Re: **3rd Party Slab Inspection Failure Notice**
Location: Lot 2 Wellers Knoll (45 Charred Oak Ct. Lillington, NC)
JDS Project No.: RDU2508814
Date of Inspection: 8/25/2025

Observations

S-1.2b
MONO SLAB
FOUNDATION PLAN

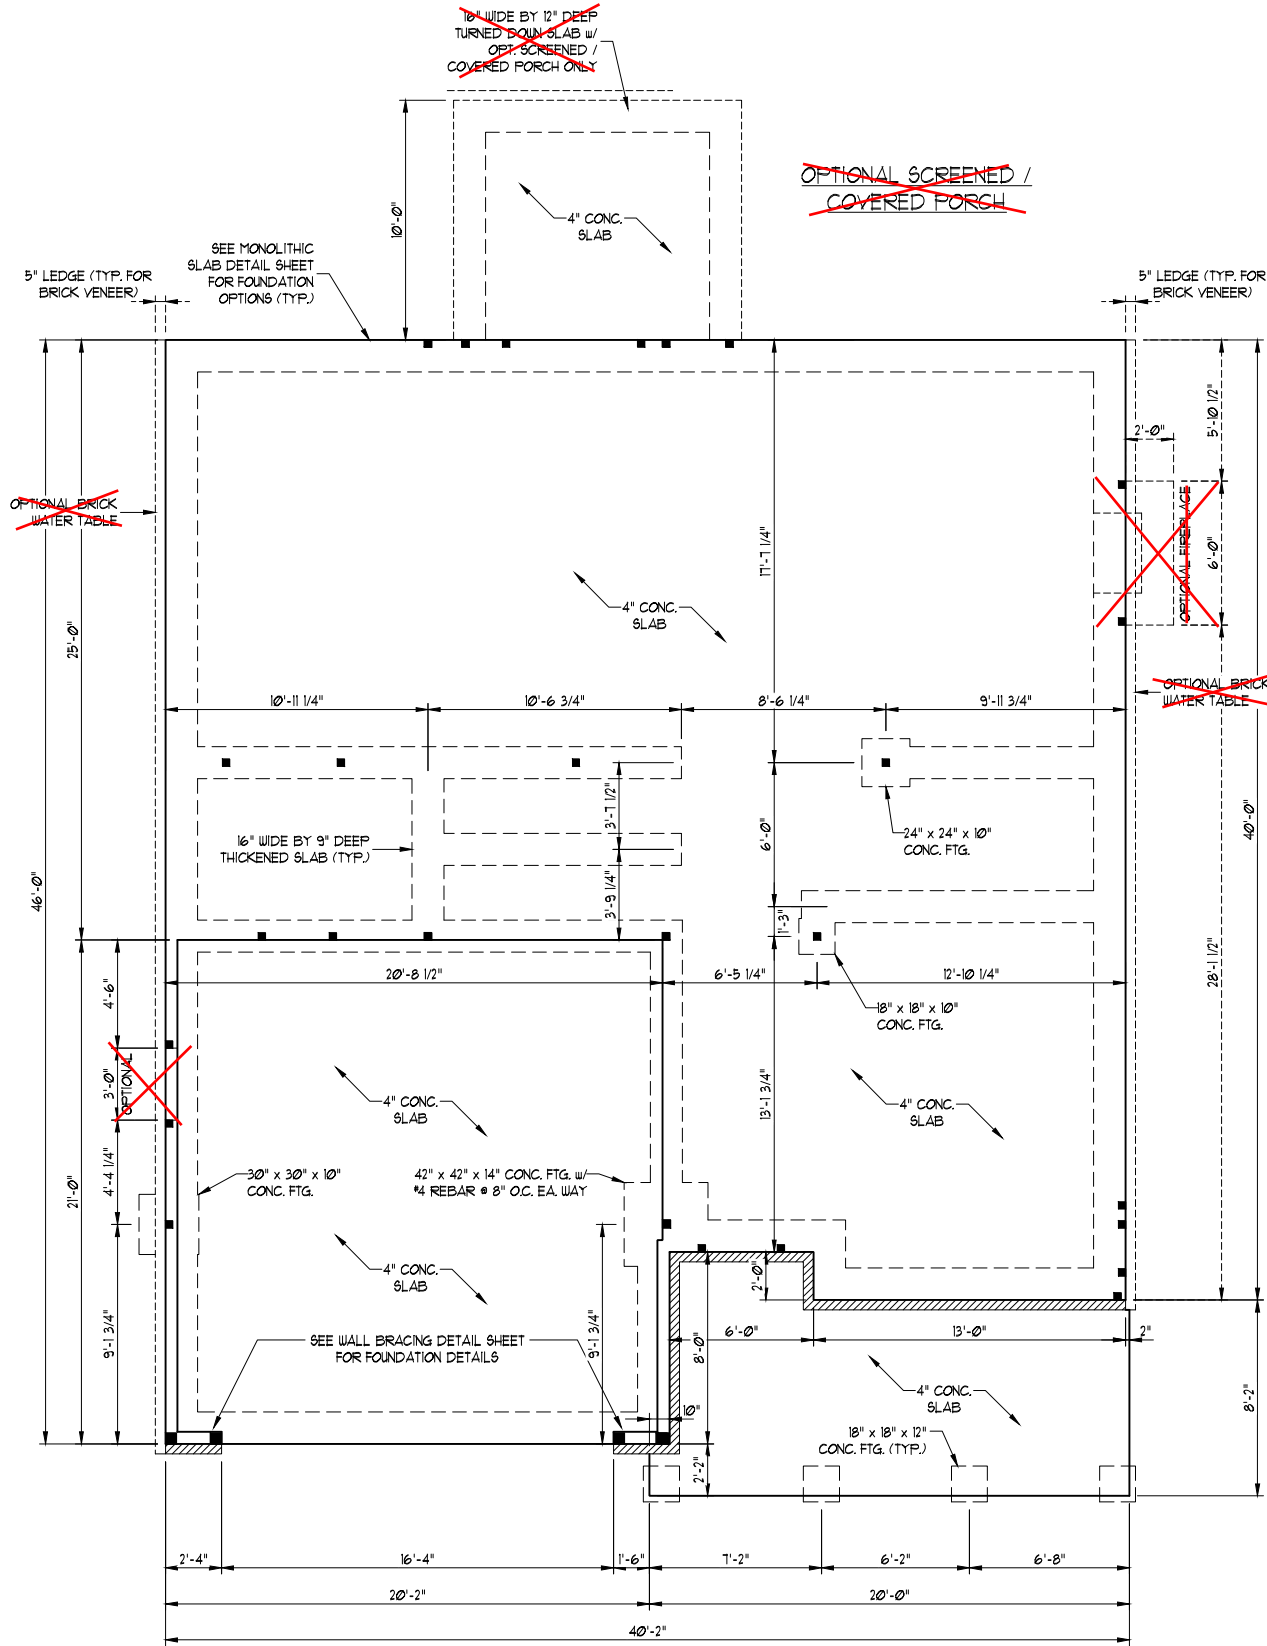
The above-mentioned lot failed 3rd party slab inspection.

- Install 30x30x10 in. lug/point load footing per plan.
- Install reinforcement at 42x42x14 in. lug/point load footing per plan.
